Planning & Infrastructure

Our ref.: MP11_0009

Subject: Exhibition of Miranda Dental Hospital – 84-86 Kiora Road, Miranda Sutherland Shire Council (MP11_0009)

SCHEDULE 1 – KEY ISSUES

south elevation
kiora road scale: 1:100

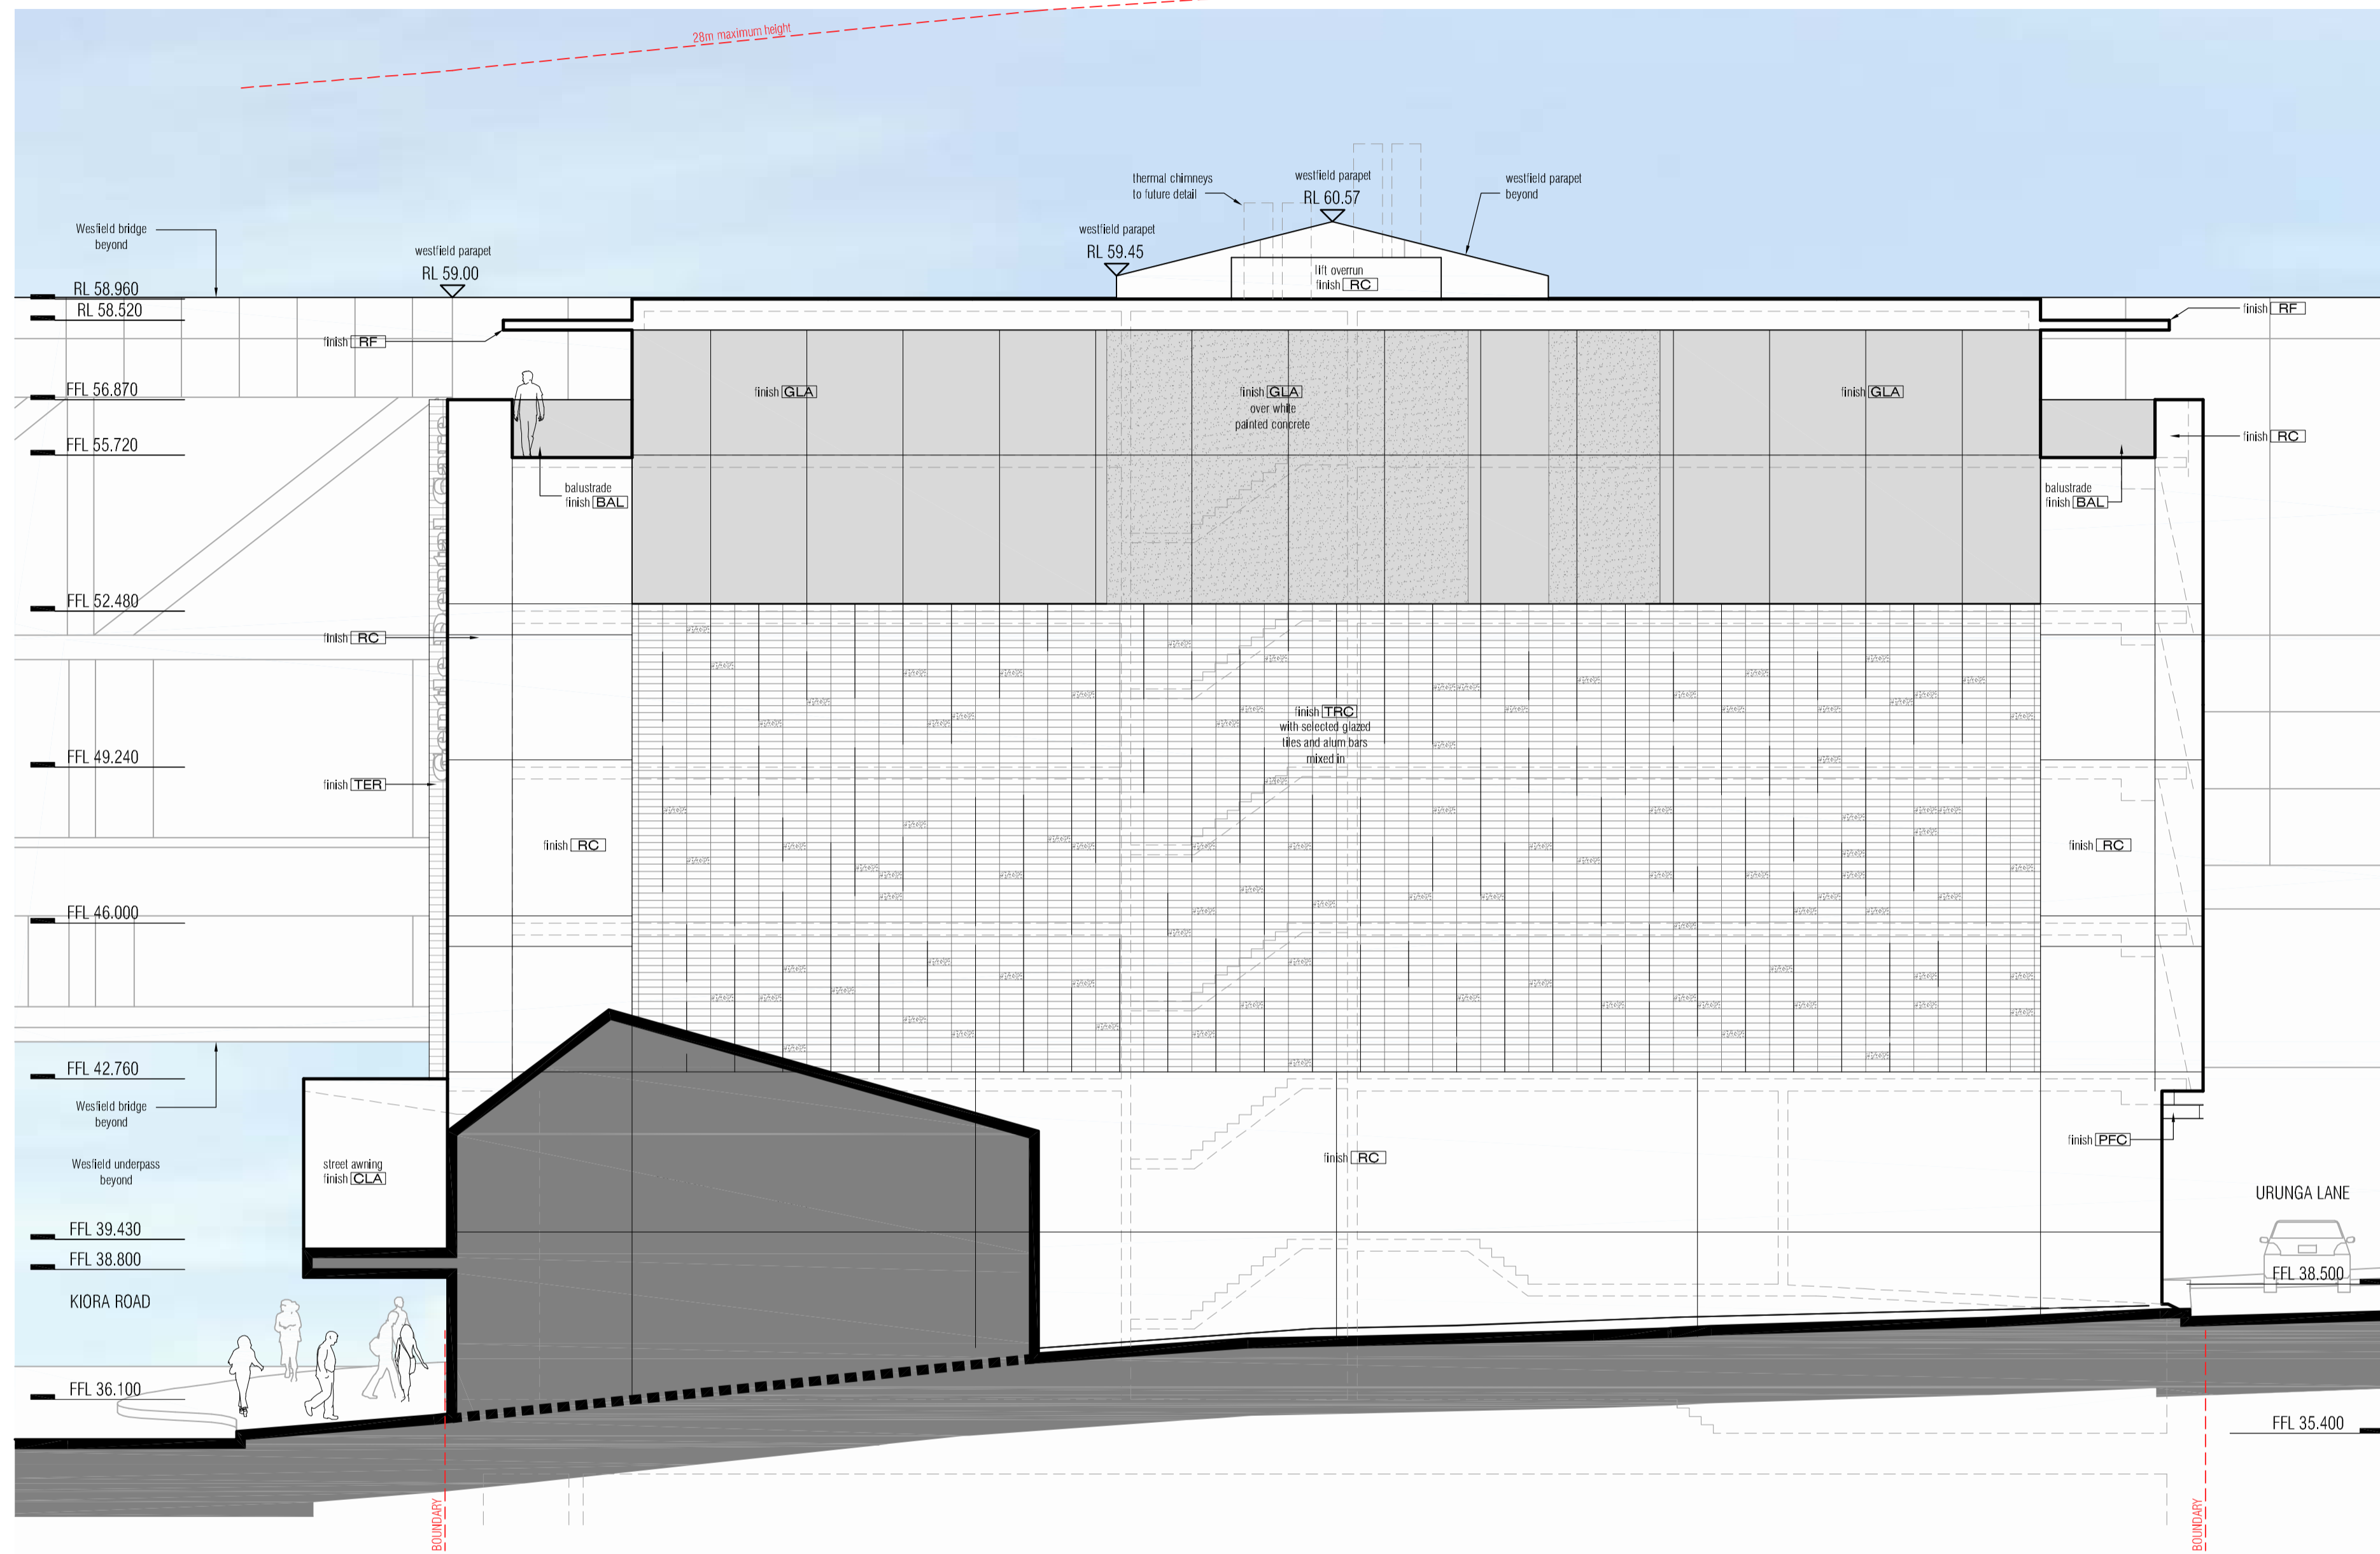
- Consideration of a setback at the ground floor to accommodate the provision of a pedestrian colonnade at Kiora Road, to provide an appropriate pedestrian linkage between the railway station and Westfields Shopping Centre.
- Further consideration of the upper level treatment of the southern elevation to limit the future impact of any redevelopment of adjoining sites to the south, to the development.
- Consideration of greater articulation to the southern elevation to prevent a sheer street wall at the lower levels prior to any redevelopment of adjoining sites to the south.
